ITEM 4.1 (c)

Issue/ Objection:
Car Parking

**85 Harrington Street
The Rocks
GOLDEN AGE & HANNAS THE ROCKS**

TITLE
**RESPONSE TO DoPE
ITEM 4.1 (c)**

For Information

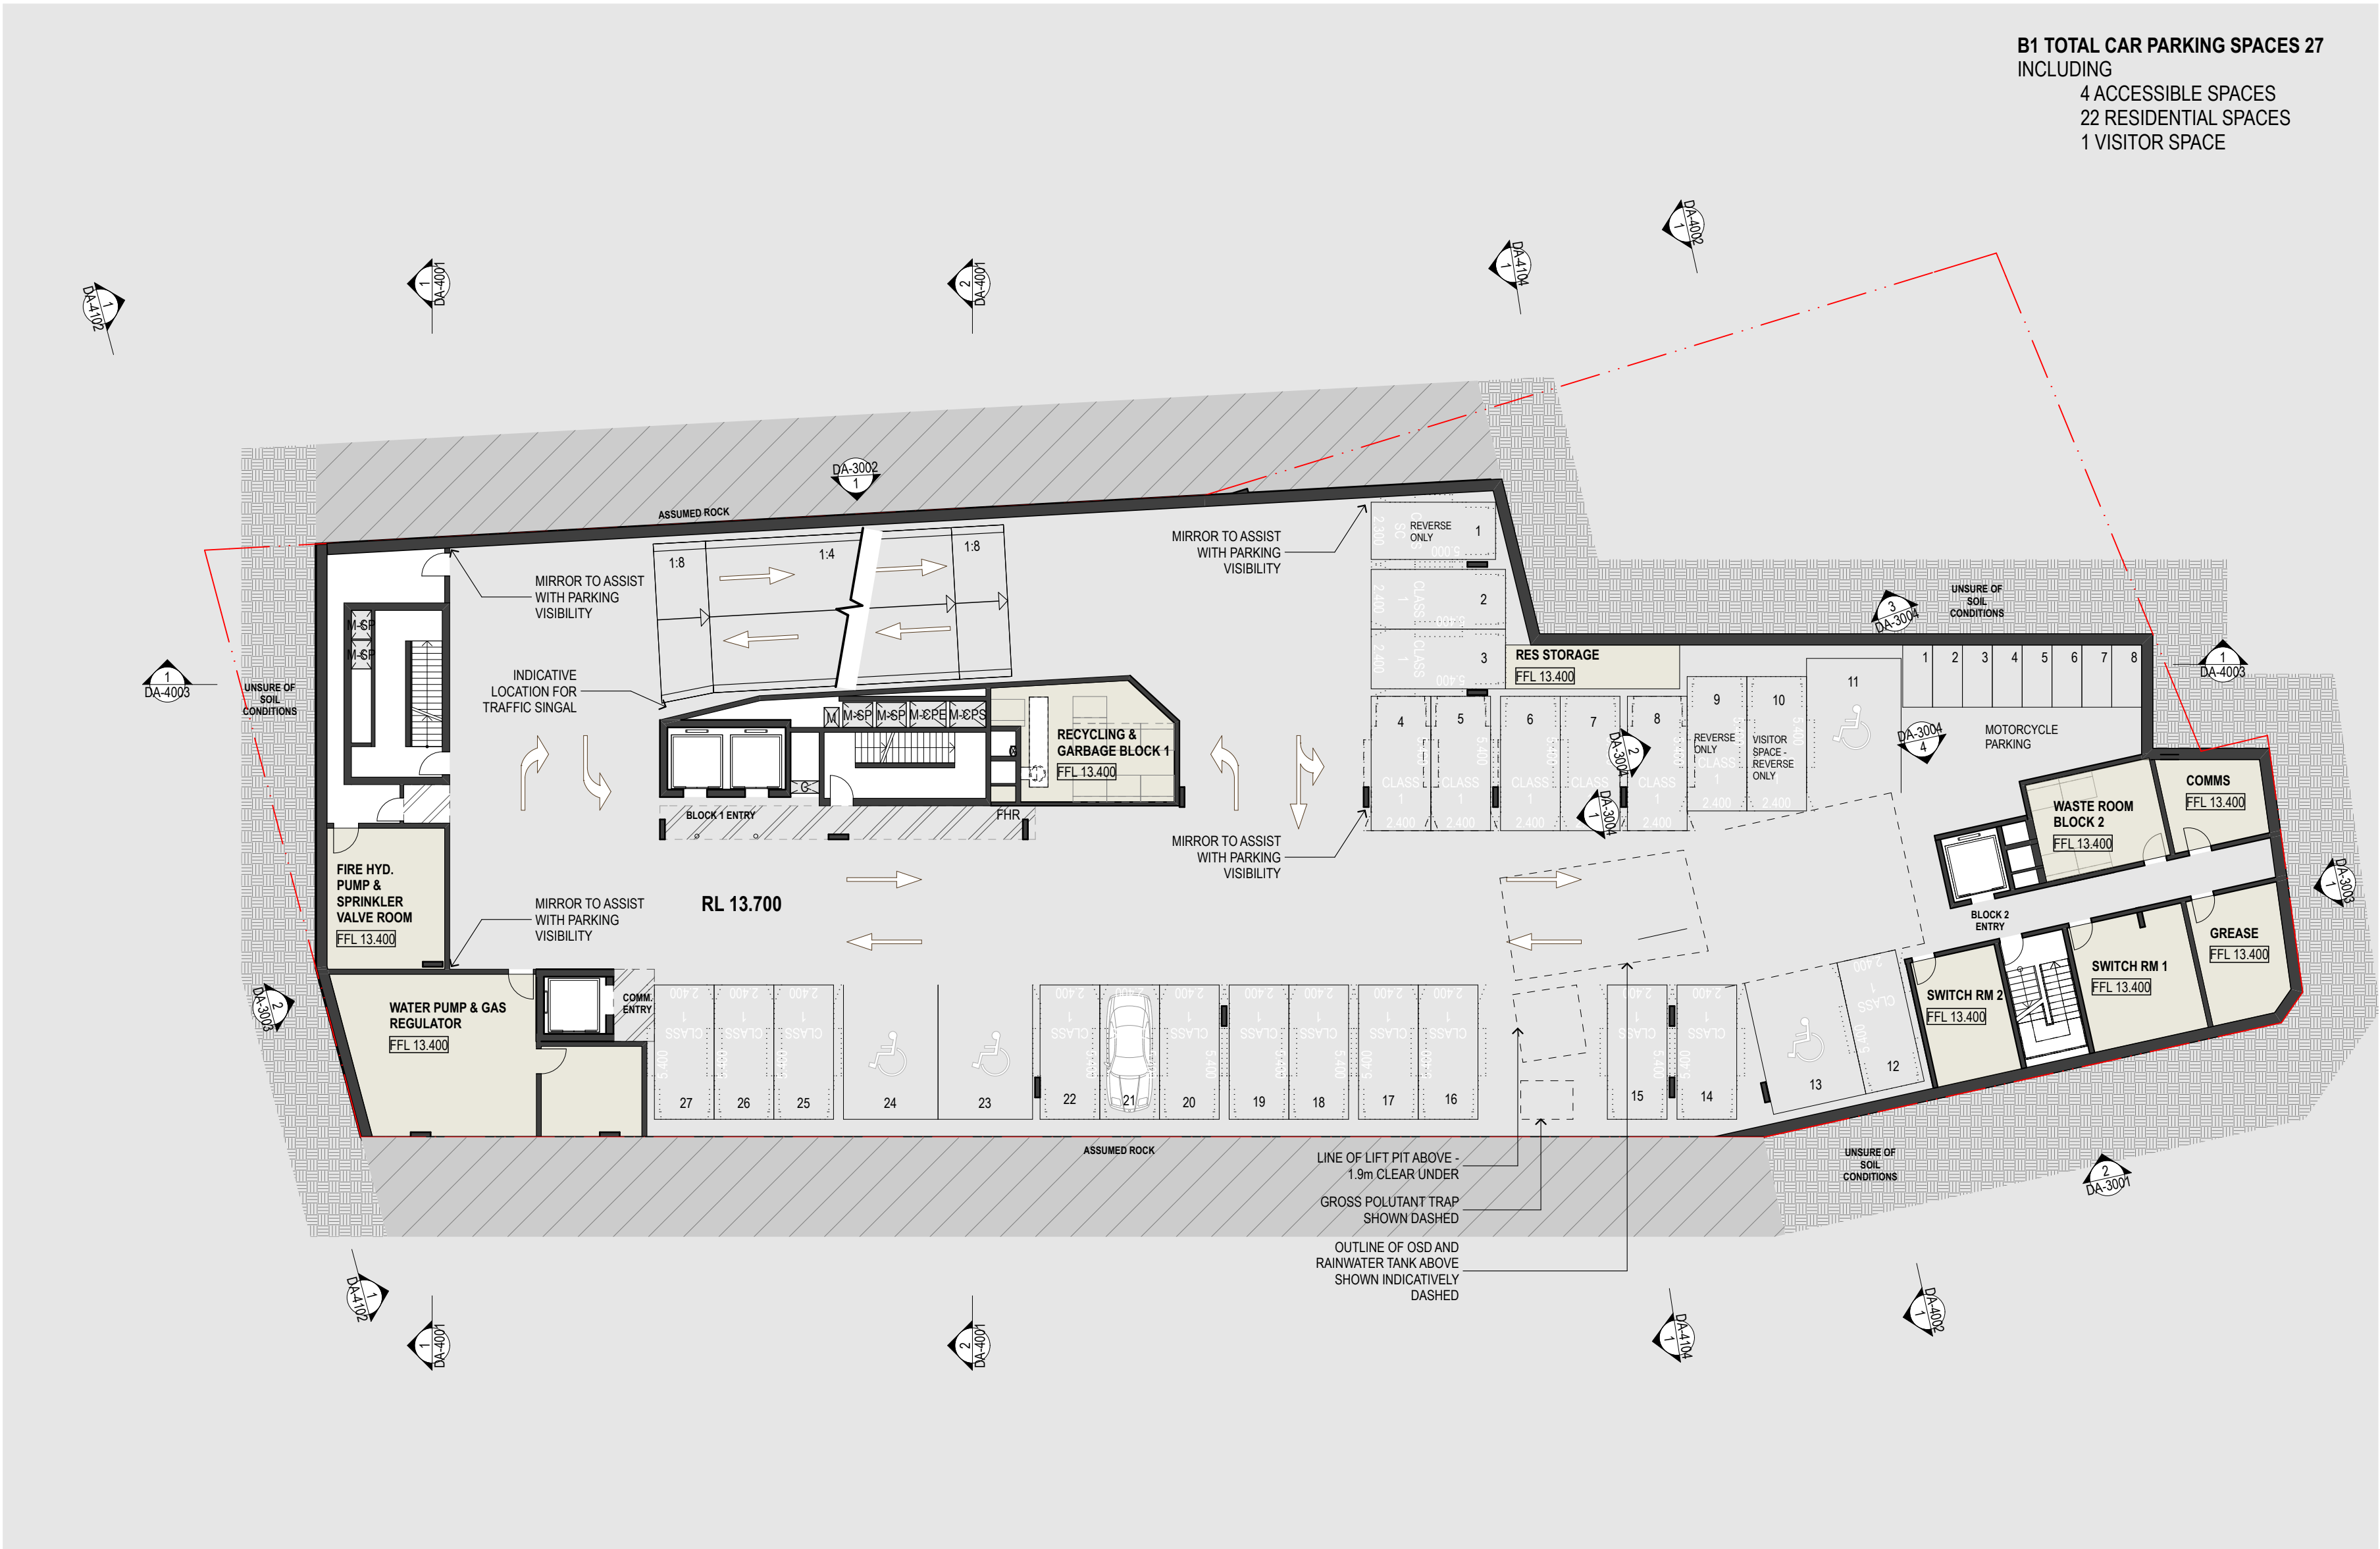
Description:
Given the location of the site within the CBD and close proximity to a variety of public transport nodes, consideration should be given to further rationalisation of the proposed number of residential car parking spaces.

Response
Refer to drawings and report provided by the traffic consultant.

The internal configuration of the basement car park and loading areas have been designed in accordance with the both AS2890.1, AS2890.2 and AS2890.6.

In our TIA dated August 2017 comments were made in relation to limited queuing area which was commentary in relation to a superseded design for the development. It is noteworthy that the proposed development provides a two way ramp which ensures that queuing will not occur on-street. Swept path analysis confirming passing opportunity of a B99 & B85 design vehicle is provided in **Attachment 2** for reference.

The basement design has been amended so that the proposed development now provides a total of 114 bicycle parking spaces in accordance with the requirements set out in the City of Sydney's LEP 2012 and as detailed in **Table 4** overleaf. The bicycle parking spaces have been indicated on the amended plans which are included in **Attachment 3** for reference. Please note that commentary on the End of Trip Facilities will be provided by the architect.
